Address: 18, South Brook Gardens, Mirfield, WF14 8LS

Application number: 2026/CLD/91507/E	
What is the application for?:	Certificate of lawfulness for proposed change of use of residential dwelling (Us
Address of the site or building:	12, South Brook Gardens, Mirfield, WF14 8LS
Postcode:	WF14 8LS

| drawing     | PROPOSED PLANS & ELEVATIONS                                              |             |       |

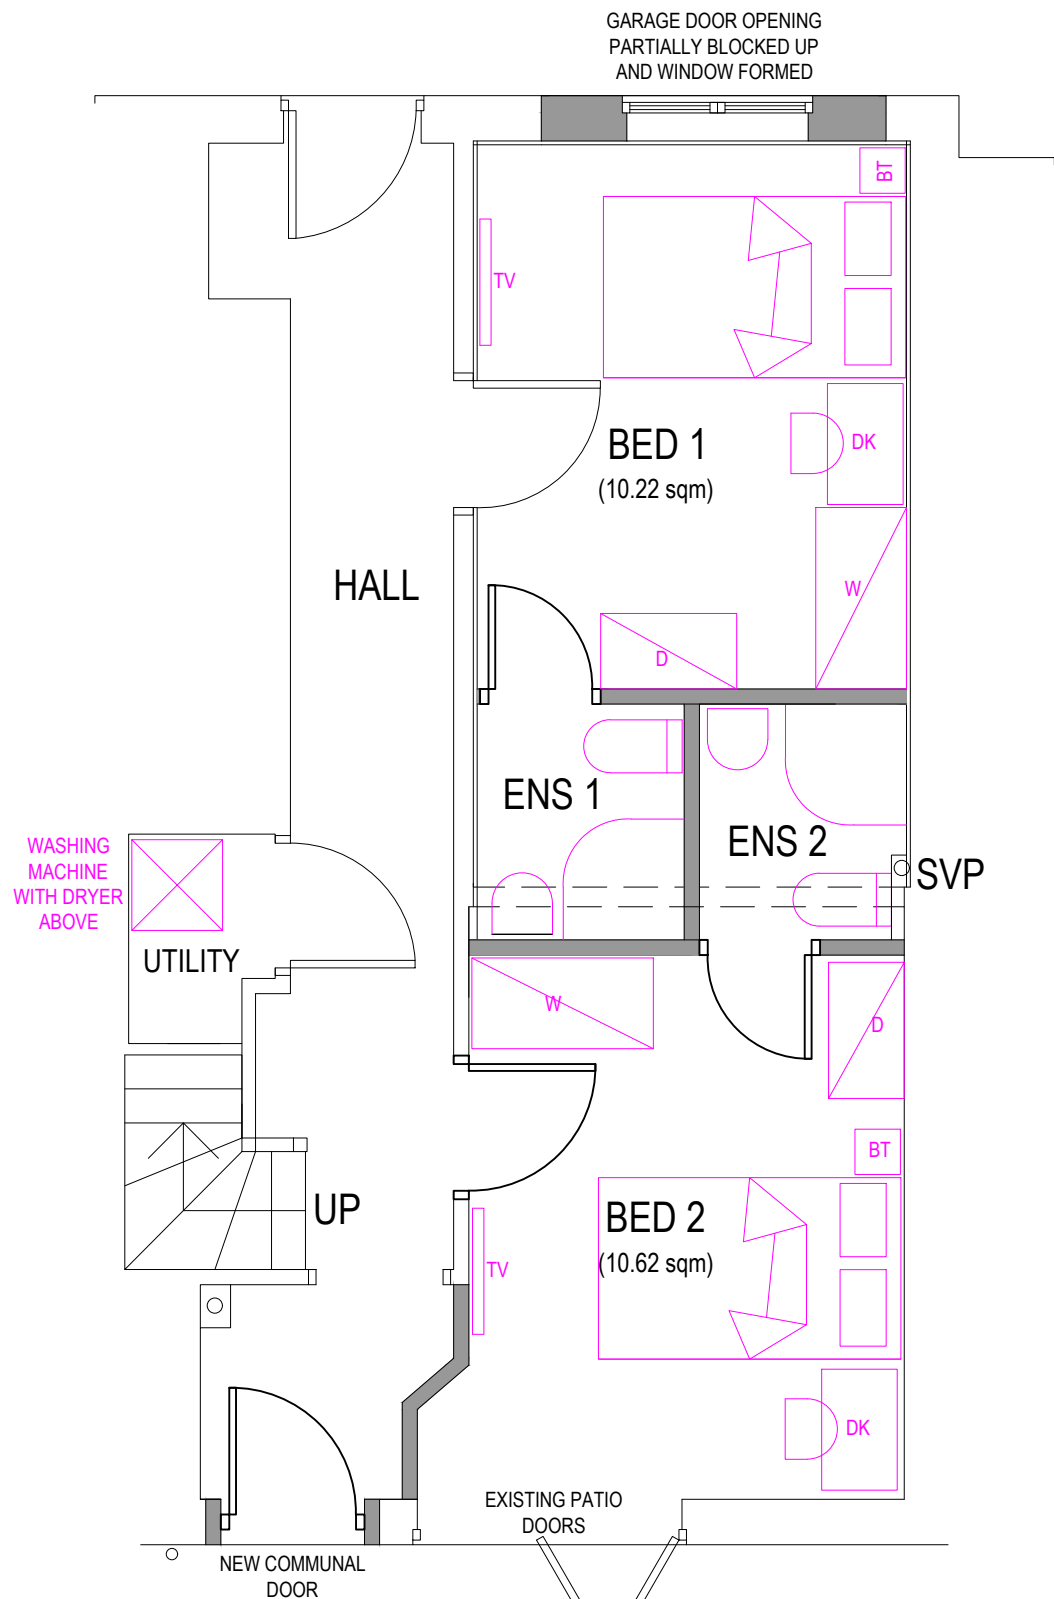
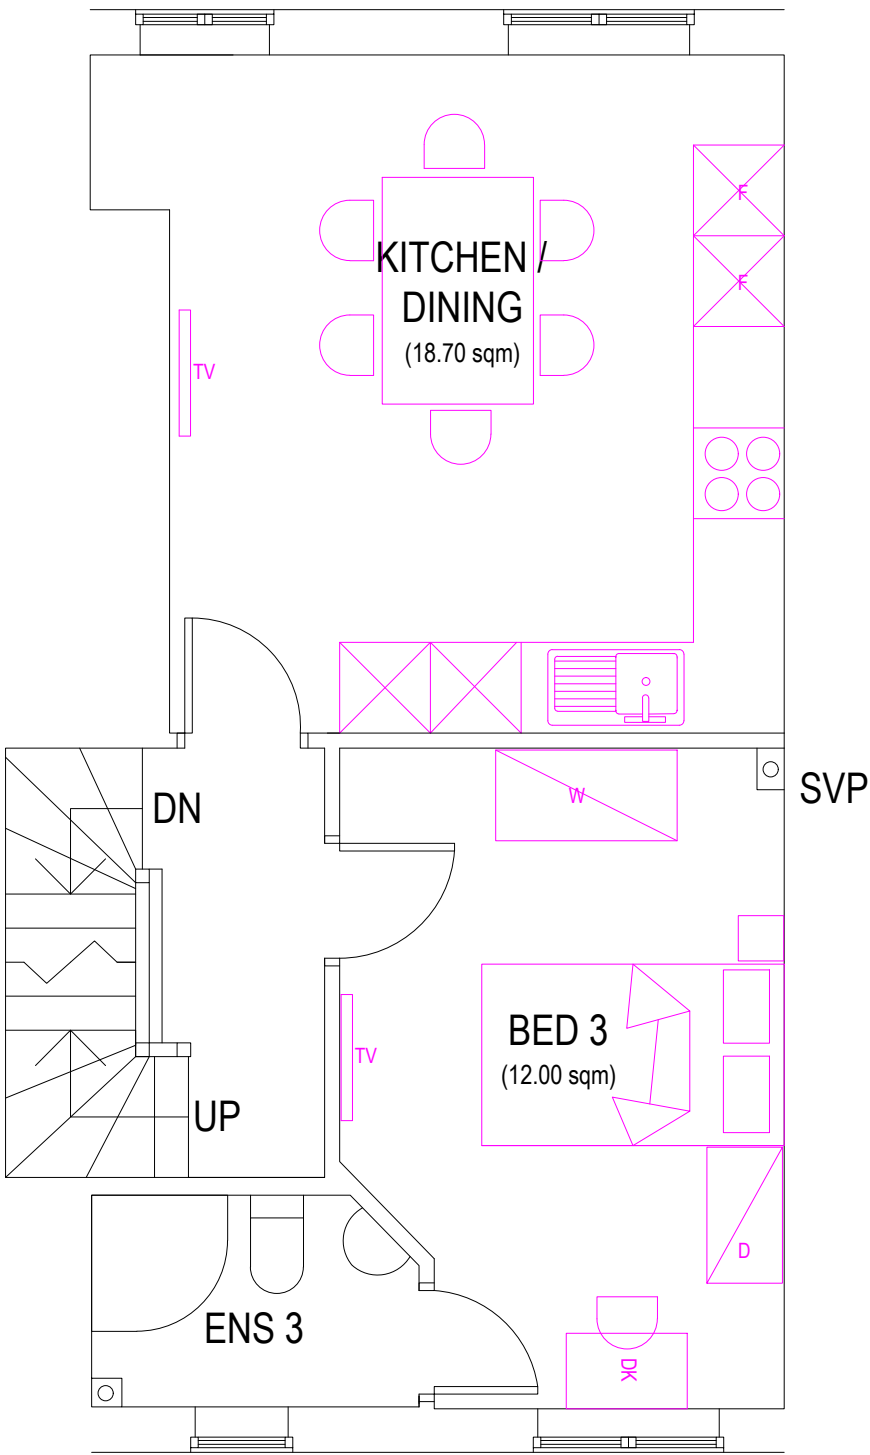
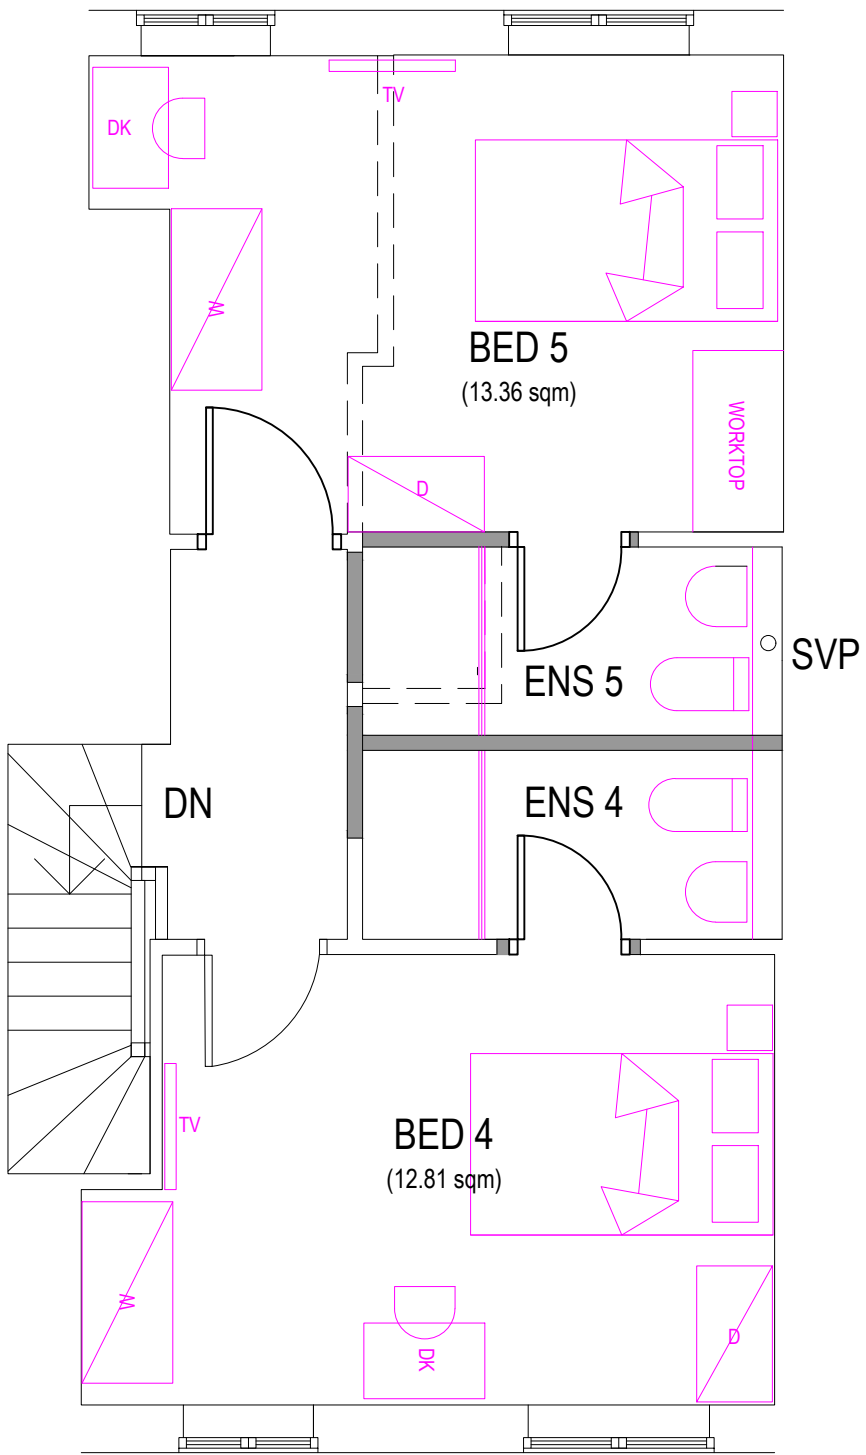
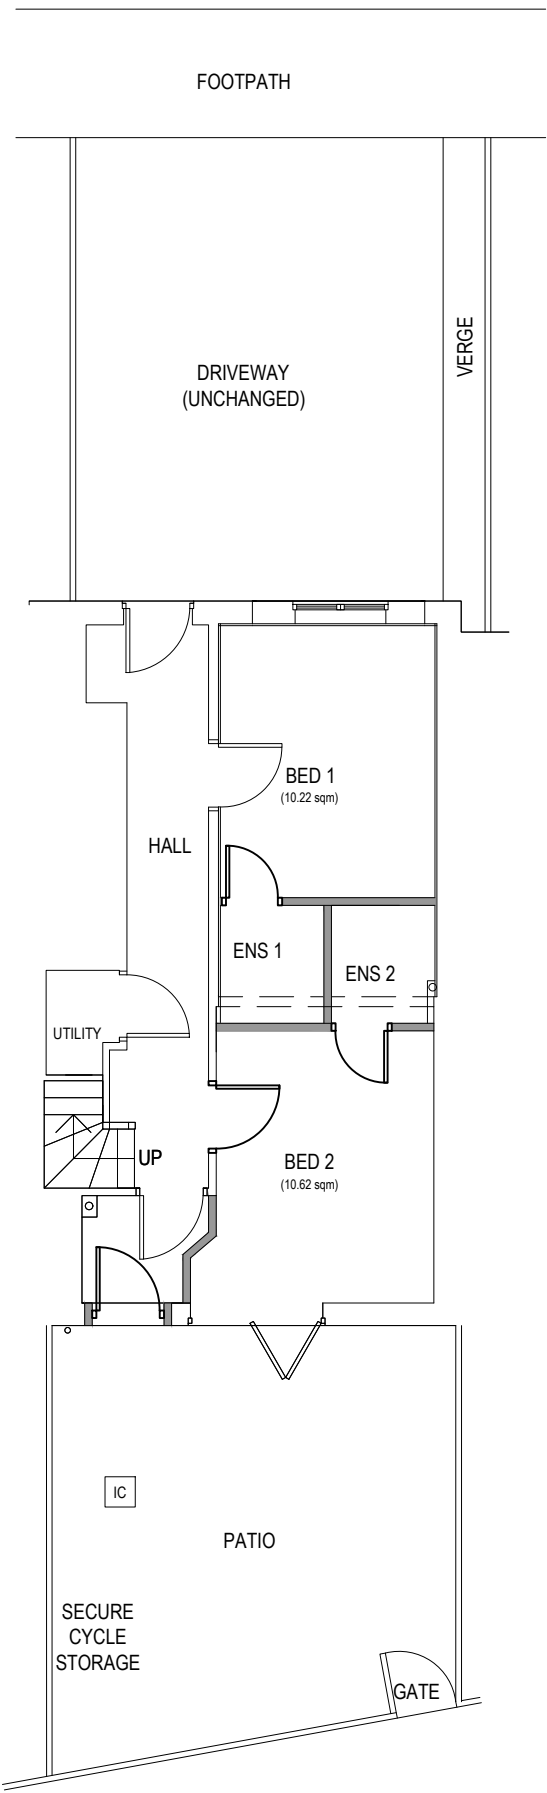
Type of comment: An objection	
Do you wish your comments to be published on the website anonymously?	No
Objection Reason: Inaccuracy of Proposed Use Class, Material Change of Use, and Extreme Over-Intensification Dear Case Officer, I am writing to formally object to the issuance of a Certificate of Lawful Development for the proposed change of use at 12 South Brook Gardens. The application seeks to establish that the property's use as a House in Multiple Occupation (HMO) falls within Use Class C4 (small HMO, maximum 6 residents) and is therefore permitted development. However, the physical configuration, specific room sizes, and inescapable infrastructure constraints of this exact site layout demonstrate that the property will operate as a Large HMO (Sui Generis). This represents a material change of use that requires full planning permission. The legal and factual grounds for this objection are detailed below: 1. Factual Intent for 10 Occupants (Sui Generis Use) Under the Town and Country Planning (Use Classes) Order, Use Class C4 permits a maximum of 6 residents. The submitted plans outline 5 double bedrooms, all exceeding 10.22 square metres in floor area. Under Section 326 of the Housing Act 1985 and Kirklees Council's own HMO Amenity Standards, a room exceeding 10.22 sqm is legally classified as a double room capable of accommodating two adults. The property is thus structurally optimized and sized to accommodate up to 10 occupants (5 rooms x 2 adults). This capacity moves the development entirely out of Class C4 and places it into a Sui Generis (Large HMO) classification, which possesses no permitted development rights. 2. Evidential Proof of a Material Change of Use (Parking and Intensification) To qualify for a CLD, the applicant must demonstrate that the change of use is not "material" under Section 55 of the Town and Country Planning Act 1990. Case law dictates that whether a change is material depends heavily on the character of the use and its physical impact on the immediate surroundings. • Driveway Capacity vs. Occupancy: The property features a private driveway capable of hosting a maximum of 2 vehicles. A 10 person occupancy layout means the physical

of hosting a maximum of 2 vehicles. A 10-person occupancy layout means the physical infrastructure on-site can only satisfy a minute fraction of potential resident vehicle demand.

- The Threshold of Materiality: The introduction of up to 10 independent adults into a single dwelling with a 2-car driveway will generate an immediate, intense overspill of vehicles onto an already oversaturated public highway. This level of external disruption changes the character of the site from a quiet residential dwelling (C3) to an intense commercial lodging house. This proves that a material change of use will occur, stripping the development of its permitted development status.

The applicant cannot use a C4 Permitted Development mechanism as a shield for a layout clearly designed to act as a 10-person Sui Generis HMO. Because the physical plans dictate an intensity of use that cannot logistically or legally operate within C4 limits, the proposal is factually incorrect and not lawful.
